# Department for Transport

### **Application by Highways England (“the Applicant”) for an Order granting Development Consent for the A303 Sparkford to Ilchester Dualling.**

#### **REQUEST FOR COMMENTS FROM THE APPLICANT AND OTHER ADDRESSEES ON THE APPLICATION FOR THE PROPOSED A303 SPARKFORD TO IICHESTER DUALLING.**

Drawing Title
**FIGURE 11.4
NOISE LEVELS IN THE DO MINIMUM DESIGN YEAR
LA10, 18HR [dB] - SHEET 1 OF 4**

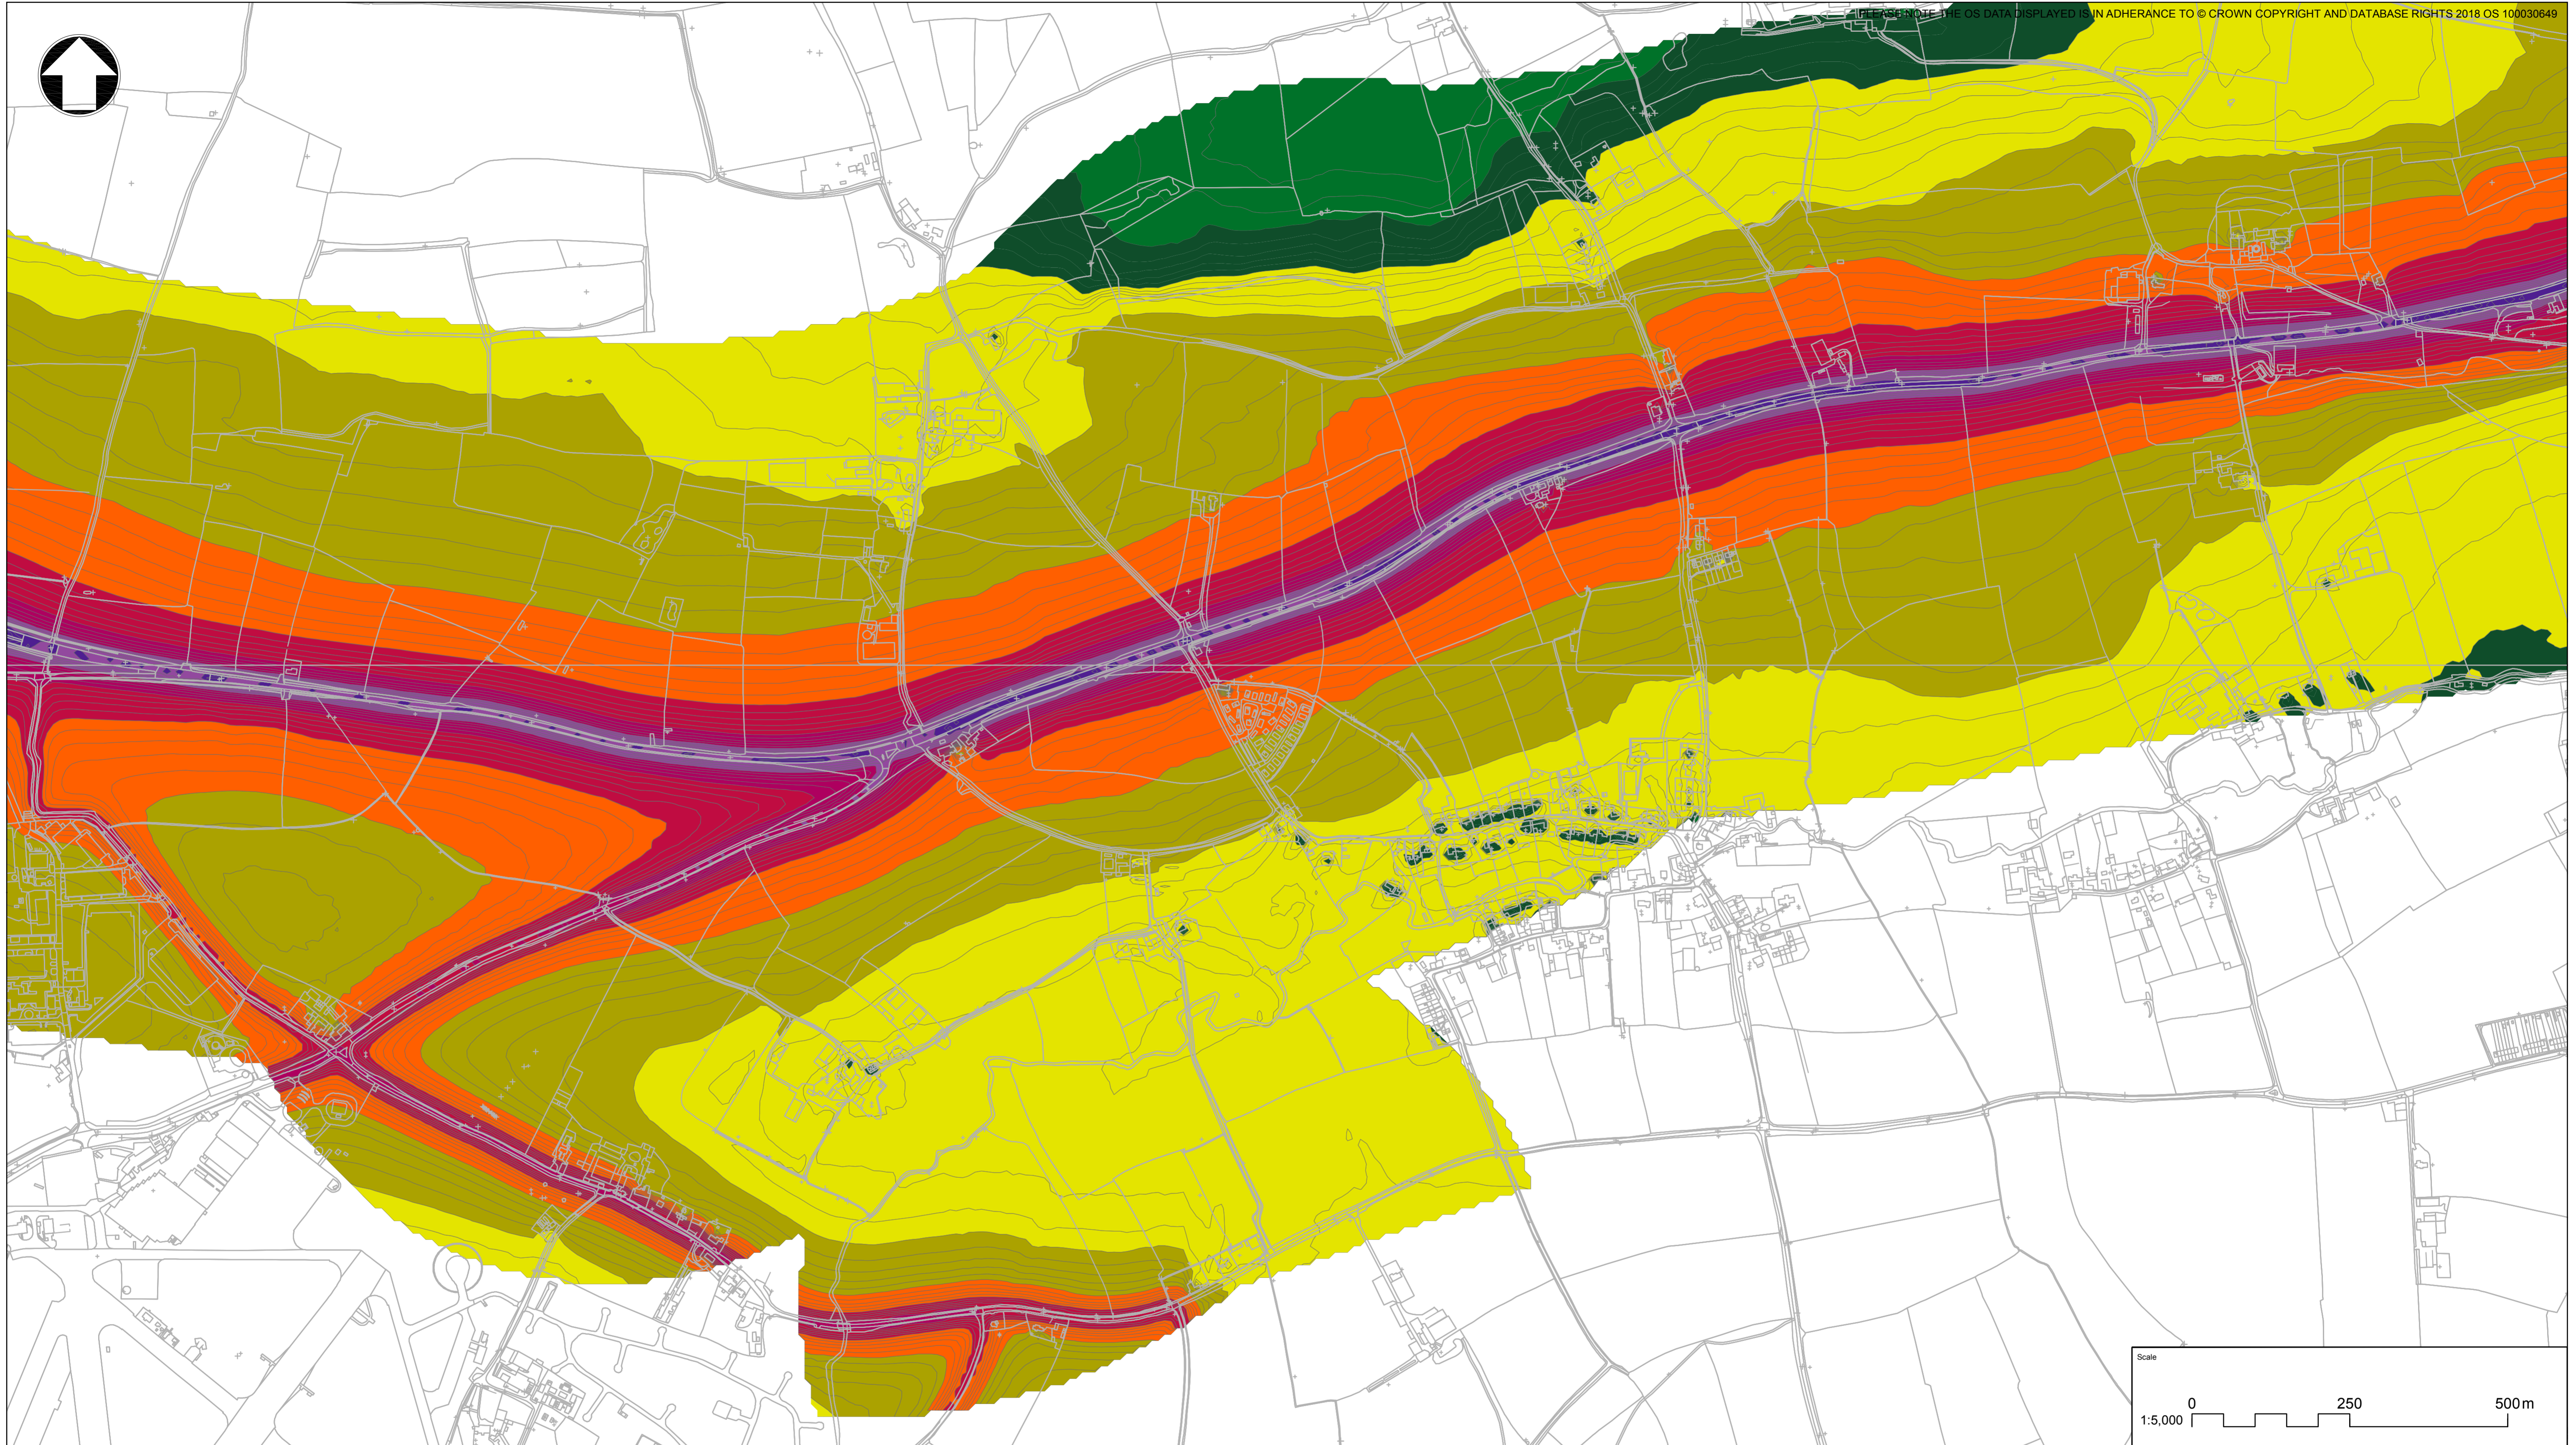
The Secretary of State invites the Applicant to provide further evidence that residential receptors, in particular, the consented residential development at Long Hazel Park and Sparkford High Street, would not be subject to a Significant Observed Adverse Effect Level (“SOAEL”) in accordance with the Noise Policy Statement for England, including details of any mitigation measures necessary to achieve this.
